# CITY OF ALBUQUERQUE

February 7, 2023

**RE: 3020 Rio Grande Blvd. NW**  
**Grading and Drainage Plan**  
**Engineer's Stamp Date: 01/30/23**  
**Hydrology File: G13D030A**

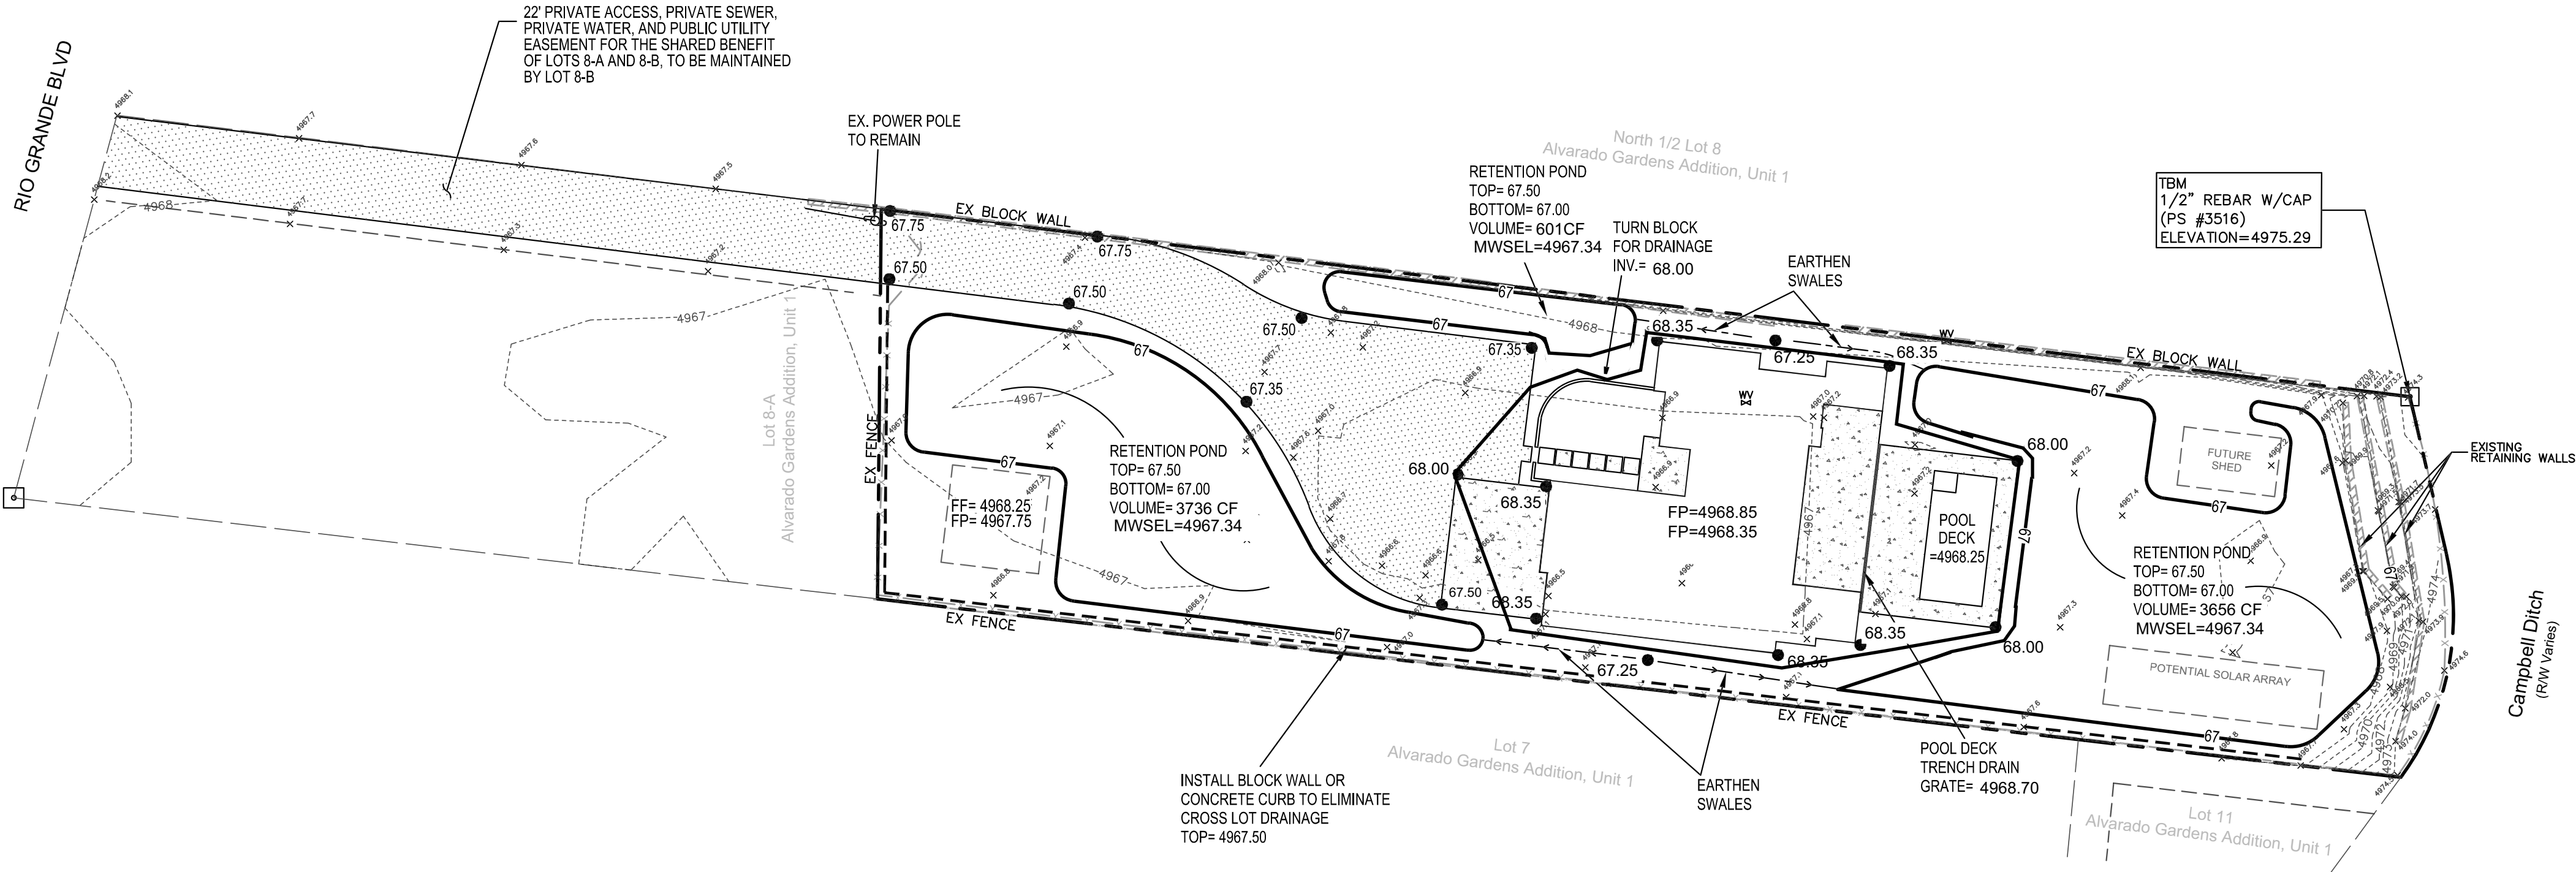
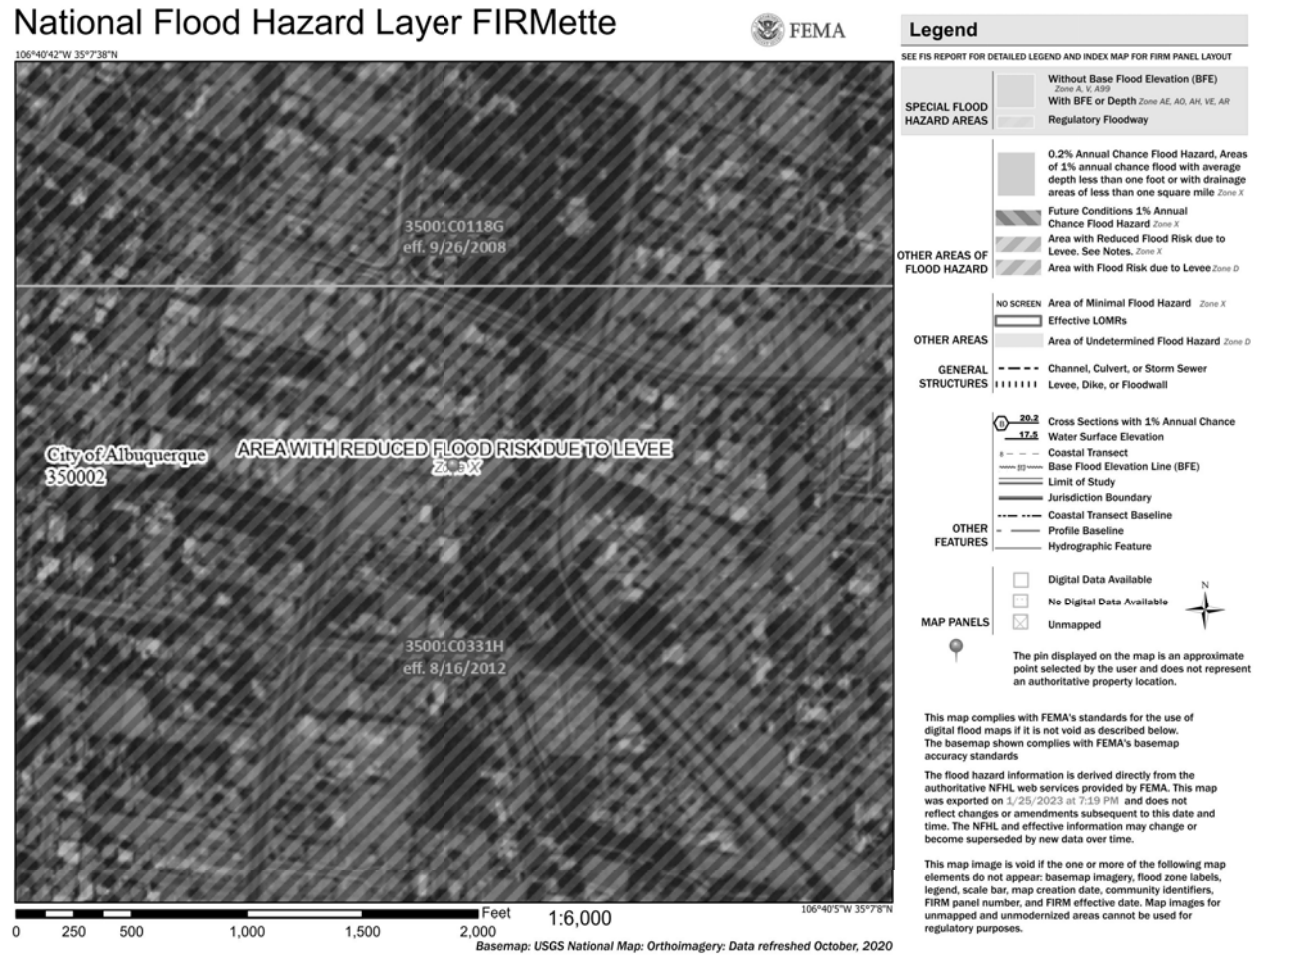
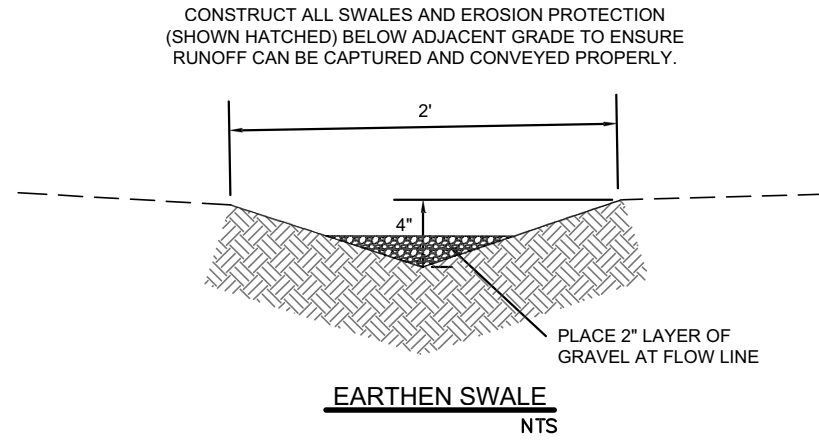
1. Please provide survey information and grading all the way to Rio Grande Blvd.

2. Please label Rio Grande Blvd. on the drawing.
3. In the drainage writeup, it states that this site is a redevelopment of a previously developed lot. This is false. The lot was subdivided for a development that never happened. Also, it states, that the ponds will overflow to the street in the event of a storm exceeding the 100-year event, this is also not true. Rio Grande Blvd is a few feet higher than the site at the Right-of-Way and this site drains to the east towards this lot. More than likely this site will actually drain to the Campbell Ditch when it exceeds the 100-year event.

4. Since this site is in the Valley region, please follow Article 6-5 Valley Drainage Criteria of the DPM. The following conditions must be applied to the site:

- a. The maximum percent impervious of the lot and the contributing area may not be greater than 45%.
  - b. Pad elevation shall be a minimum of one (1) foot above the 100 year 10-day stormwater surface elevation.

- c. The flow between the front yard and back yard cannot be obstructed. The stormwater must be allowed to equalize to the same level between the front yard and back yard.

- d. A permanent perimeter wall or barrier around the development is required to contain the 100 year 24 hour storm developed runoff.
